Response to Planning Application

From: Arun District Council Greenspace

Application ref: R/102/20/PL

Description: 1 No. detached 5-bedroom house with attached single storey double garage & carport.

Tree Retention and Protection Plan

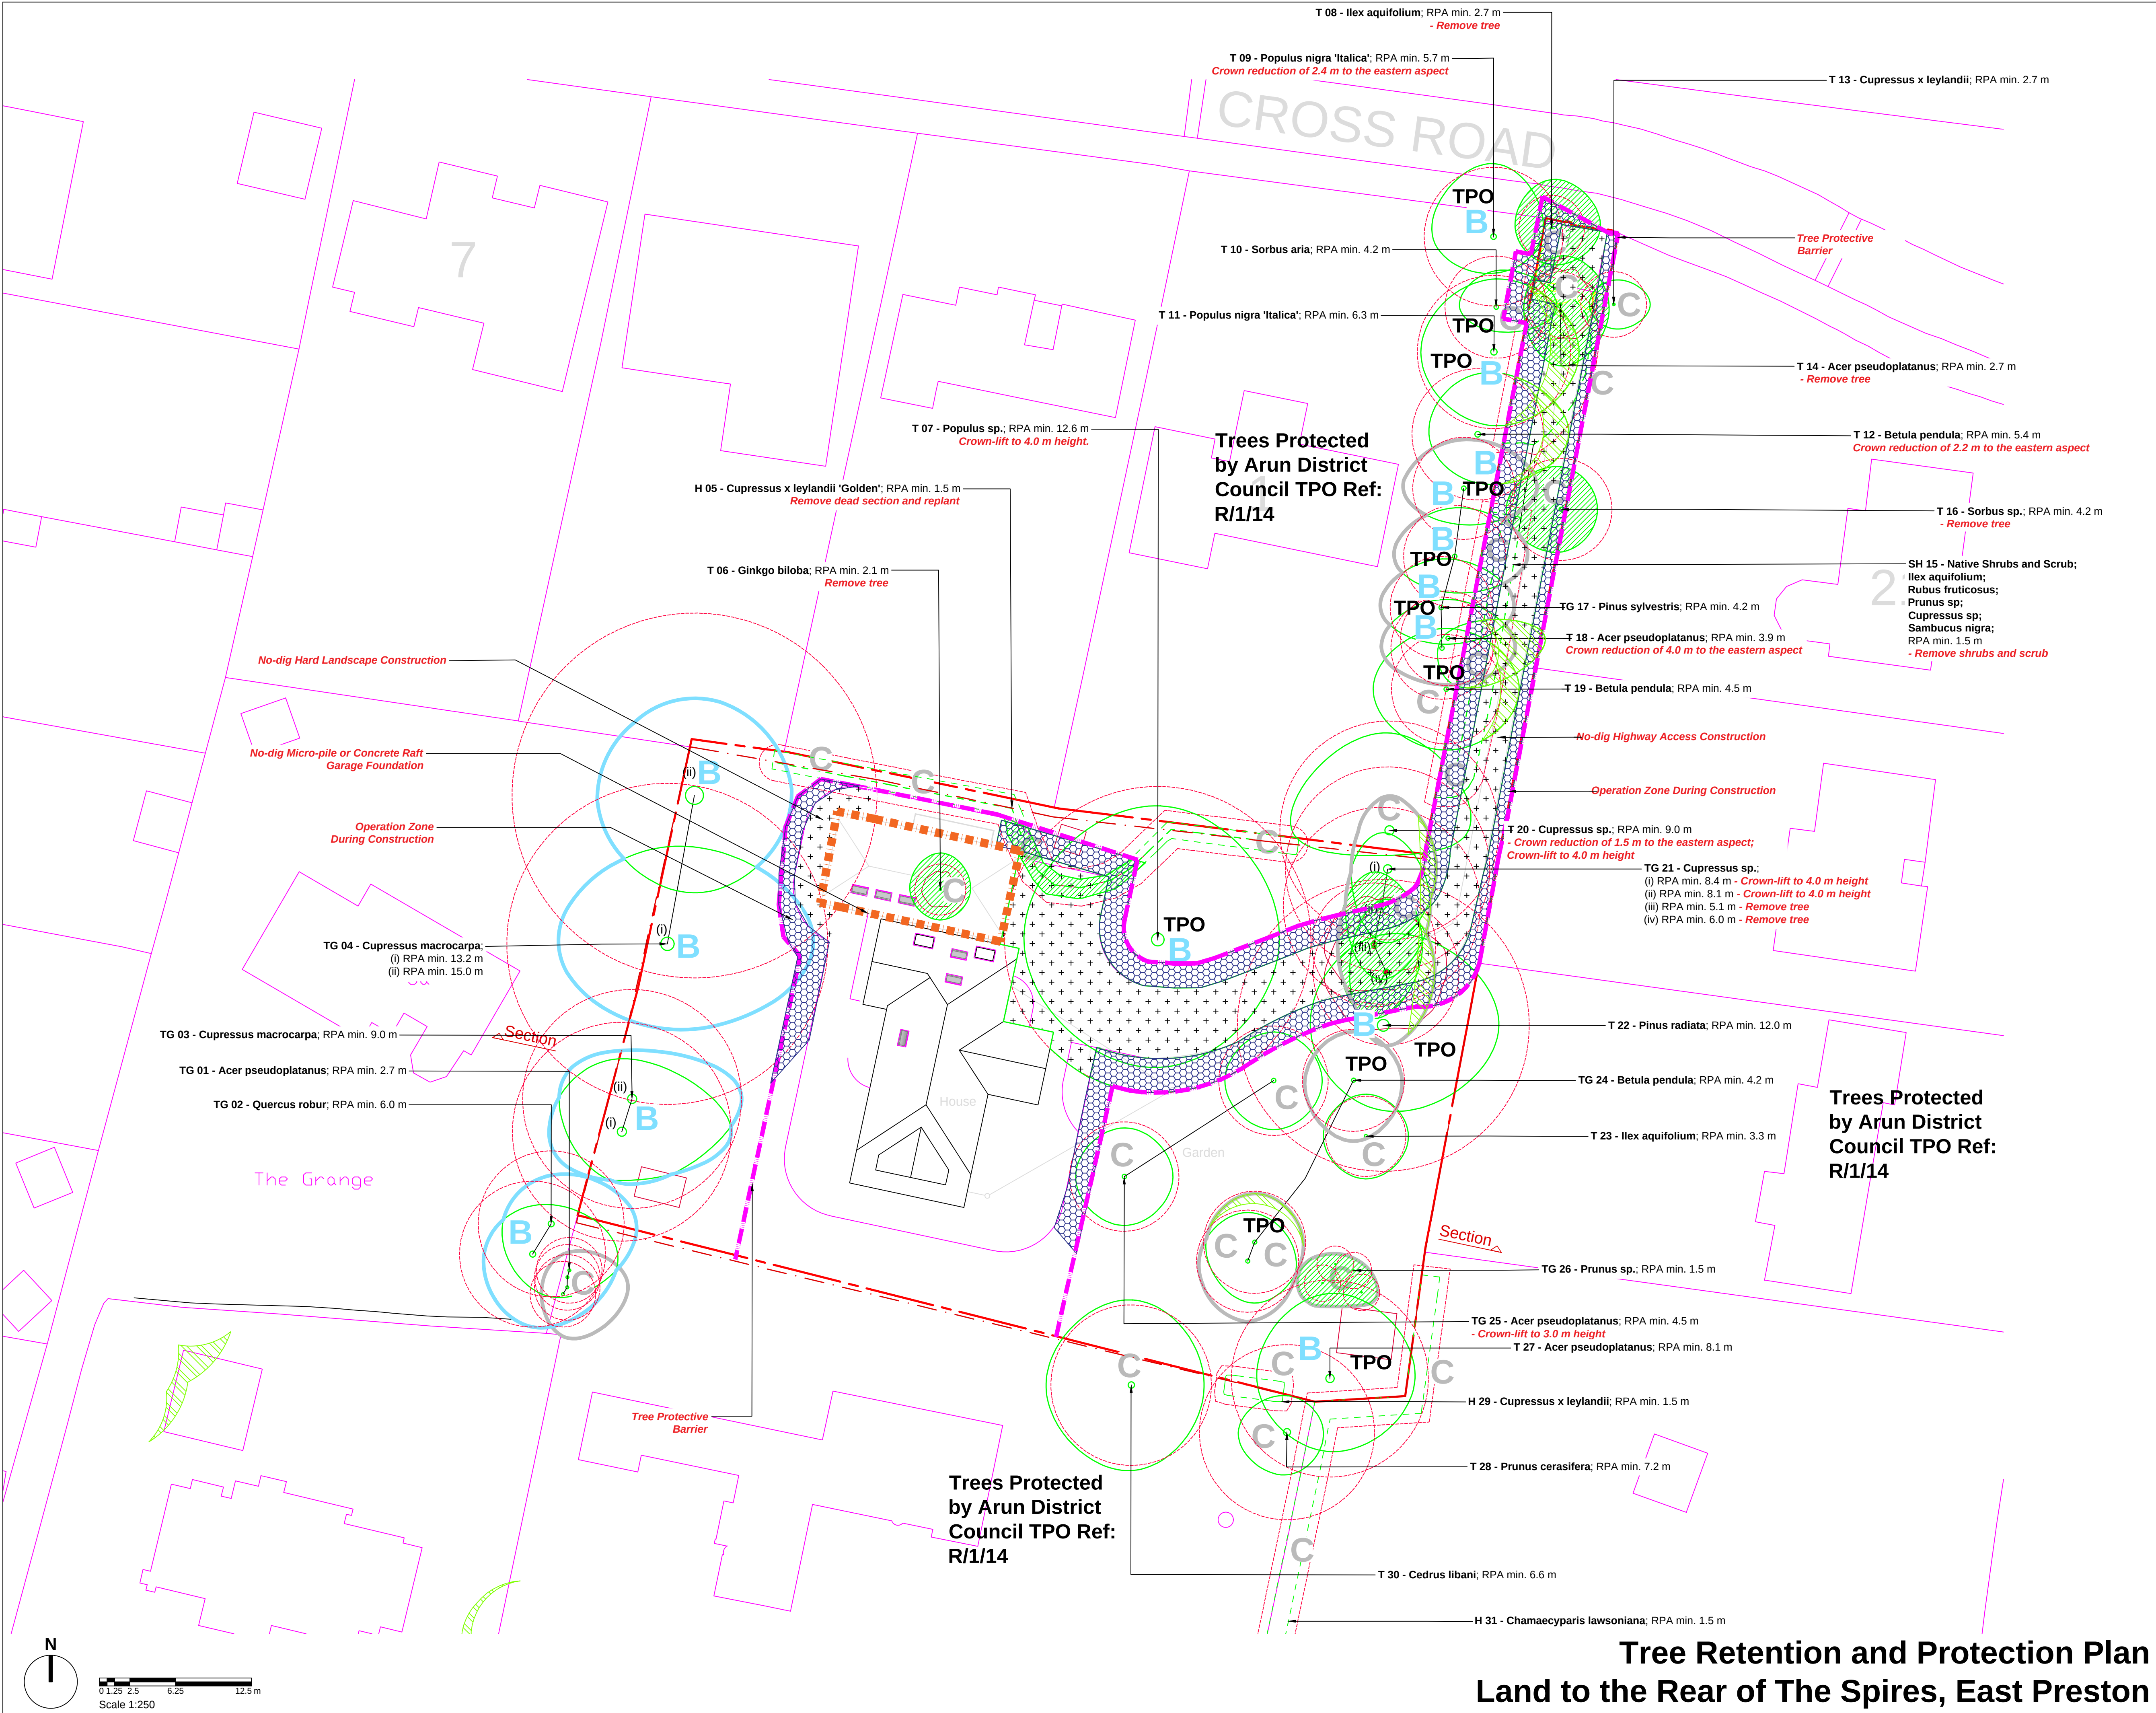
The NPPF para 124/127 relate to good design principles which equally apply to small infill development. The site layouts and plans submitted have taken into account the numerous trees within and adjacent to this site where significant TPO'd trees have been identified. Particularly of note are the Macrocarpa TG03 and TG04 trees. Tree protection plans have made reference to indicative planting alongside tree retention. These details would require expanding in the form of a detailed planting plan and specification detailing species choice, actual plant quantities, planting densities and size at time of planting. Detail should also be provided regarding existing trees and boundary planting and show those to be retained. Detail will need to be agreed re tree protection measures and any considered tree works with consultation with Arun District Councils Tree Officer.

Landscape provision to the dwelling and improvement with native species infill plus further boundary screening as required. All proposed planting should be considered and its connection for biodiversity and habitat explored, with a biodiversity net gain following development. Trees specified should be at a size which allow instant impact, but which will establish and mature as the site develops. The northern boundary has an existing boundary leylandii hedge, Macrocarpa to the western edge and possible further screening to the southern boundary for privacy required.

I would recommend no landscape objection to the proposals subject to submission of detailed landscape proposals to provide ornamental and native improvements and potential biodiversity gain. To confirm tree protection methods in relation within and beyond the site boundary that may be affected by the development proposals.
